Lower Thames Crossing

5.4.4.11 Final Agreed Statement of Common Ground between (1) National Highways and (2) Transport for London (Clean version)

DATE: December 2023
DEADLINE: 9A

Planning Inspectorate Scheme Ref: TR010032
Application Document Ref: TR010032/APP/5.4.4.11

Drawing file: TR010032 / TR010032-005281-Additional Submission - Land Plan - v6 Deadline 5 - Sheet 45 - Visual Aide.pdf

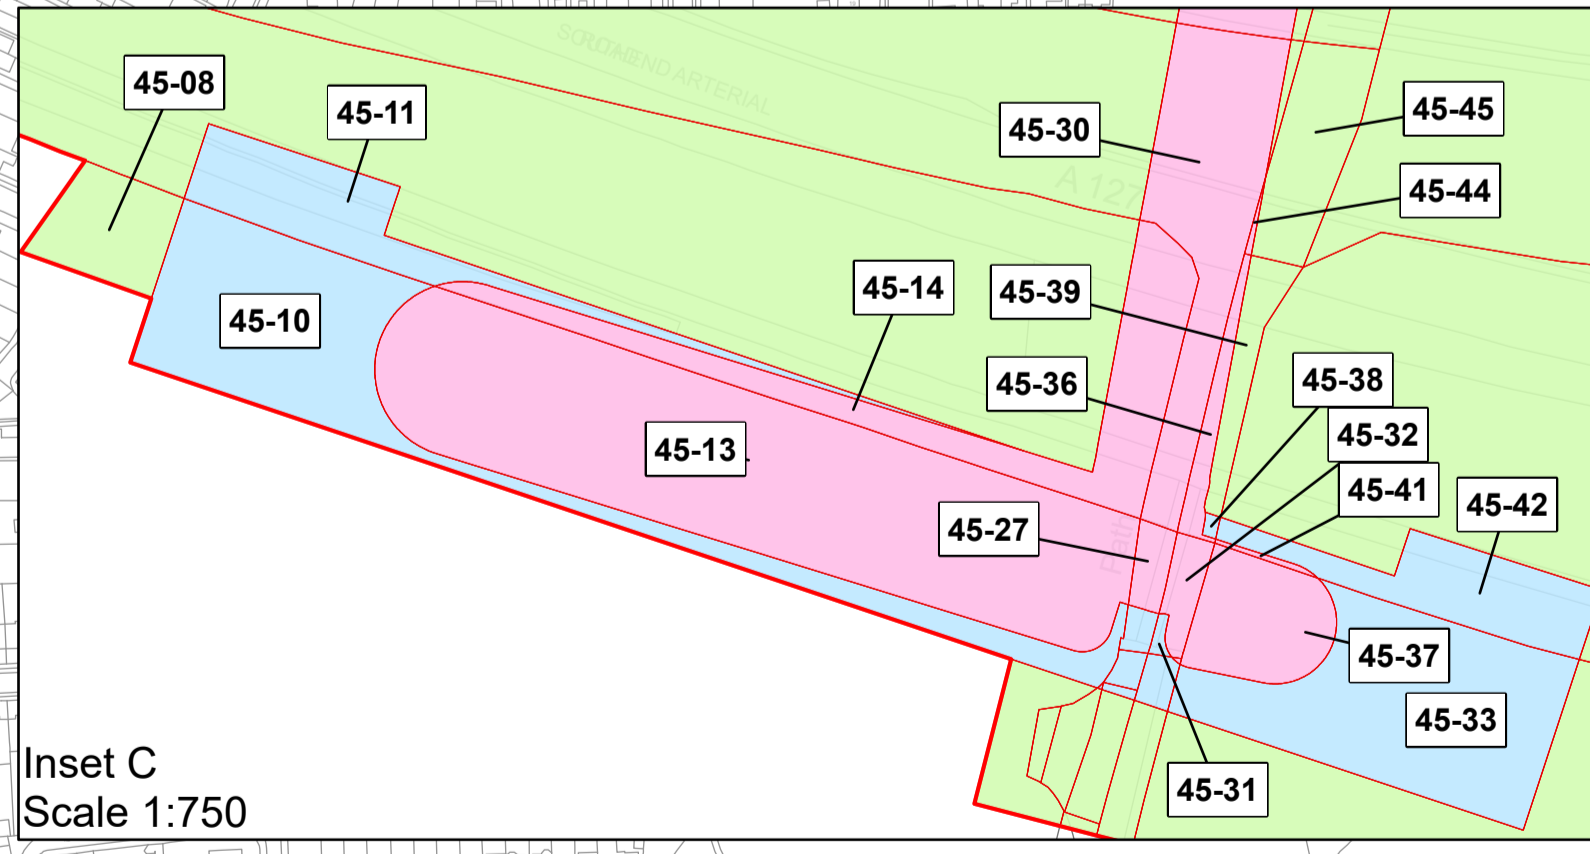
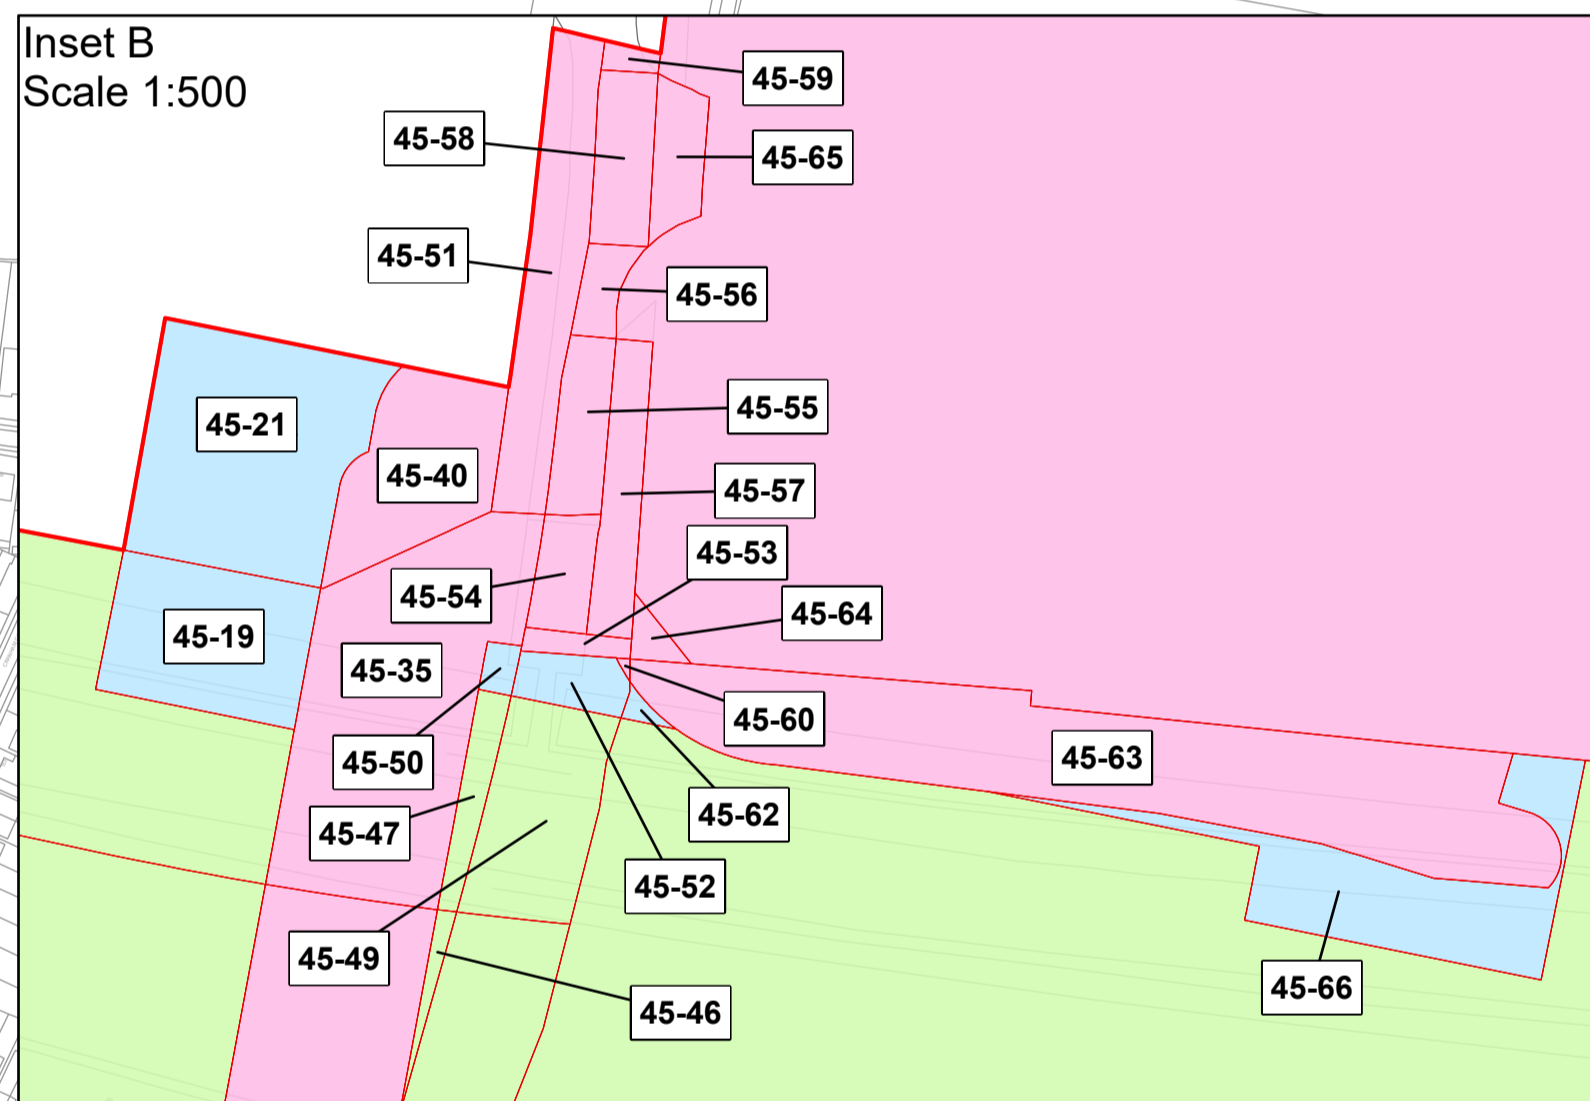
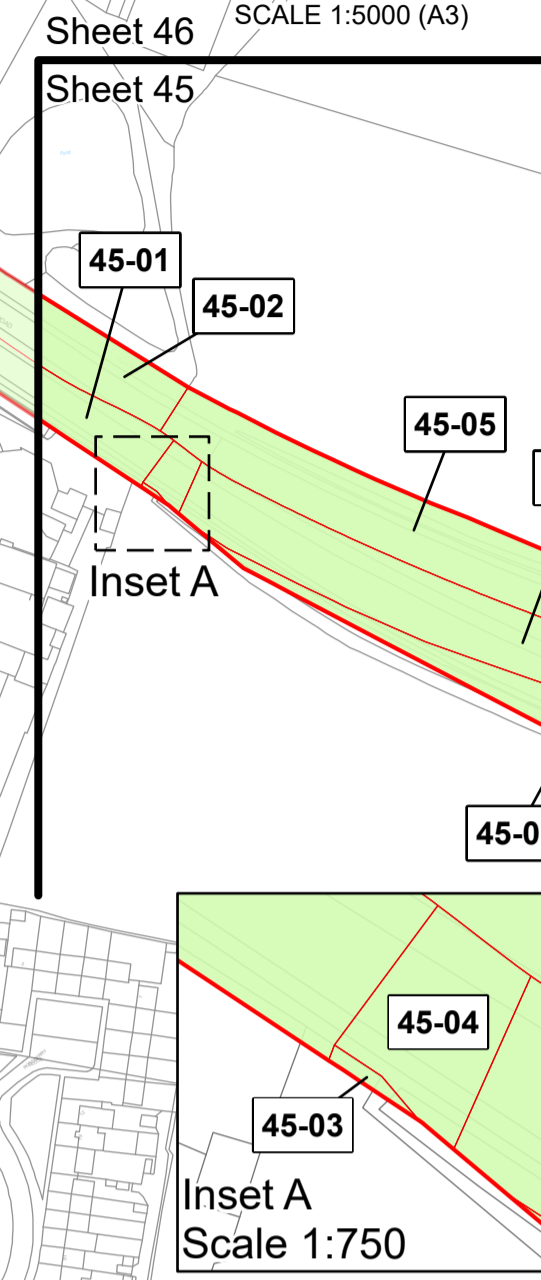
Route selection, modal alternatives and assessment of reasonable alternatives					
Route selection Route alignment	2.1.5	Transport for London does not have any significant concerns about the option assessment process and therefore agrees with the proposed route alignment.	The Applicant welcomes Transport for London's agreement with the proposed route alignment.	N/A	Matter Agreed
Consultation and engagement					
Adequacy of consultation	2.1.6	Transport for London is satisfied with the adequacy of consultation undertaken to date on the Project.	The Applicant welcomes Transport for London's comments regarding the adequacy of consultation for the Project.	N/A	Matter Agreed
Land and compulsory acquisition					
Land acquisition	2.1.7	Transport for London owns the freehold of certain parcels of land	The land use to the west of junction 29 has been amended to address these concerns and	Sheets 45 & 46 of the Land	Matter Agreed

Topic	Item No.	Transport for London Comment	The Applicant's Response	Application Document Reference	Status
Permanent vs temporary acquisition	RRE	<p>within the DCO application boundary around J29 of the M25 and relating to the A127.</p> <p>The Land Plans from the previous application documents shared with Transport for London (October 2020) showed most of the land west of the roundabout within the order limits and the TLRN as it passes the roundabout as permanent acquisition. This would suggest that National Highways intends to take on responsibility for this part of the A127. However, the draft DCO that was submitted shows that National Highways are not intending to reclassify any part of the main carriageway of the A127. Permanent acquisition is therefore not required and the powers sought should be for temporary possession only at most but even those powers should be limited.</p> <p>Where the Applicant considers it needs to acquire Transport for London highway land or rights over such land to deliver the Project, Transport for London requires that such land over which Transport for London will remain highway authority should be returned to Transport for London's ownership at no cost following</p>	<p>the majority of Transport for London's titles are now temporary use. There remain some areas where the Project requires temporary possession of land with the permanent acquisition of new rights for the diversion of utilities. Permanent acquisition of land is also required for a small section of route alignment and for the construction of the new walking, cycling and horse riding (WCH) bridge structure to the west of junction 29. It is agreed that the Applicant and Transport for London will progress discussions to return any permanently acquired land to Transport for London post construction, including the proposed WCH structure which Transport for London shall be responsible for maintaining. These issues were discussed at a meeting on 17 December 2021 (with subsequent communications between the Applicant and Transport for London Land & Property specialists) and the requirements for permanent acquisition of rights were explained and accepted. At the 2022 Local Refinement Consultation, Transport for London reported that the latest acquisition plans provided by the Applicant address many of the concerns previously raised.</p> <p>Details of the land required for the WCH bridge were discussed at a meeting on 20 March 2023 with land and property specialists and</p>	<p>Plans [Document Reference 2.2 (8)]</p> <p>Draft DCO [Document Reference 3.1 (11)]</p> <p>Design Principles [Document Reference 7.5 (7)]</p> <p>Joint Local Highway Authority Response to Applicant's Deadline 4 Submission REP4-094 [REP6-142]</p> <p>Applicant's responses to Interested Parties' comments on the dDCO at Deadline 6 [REP7-190]</p>
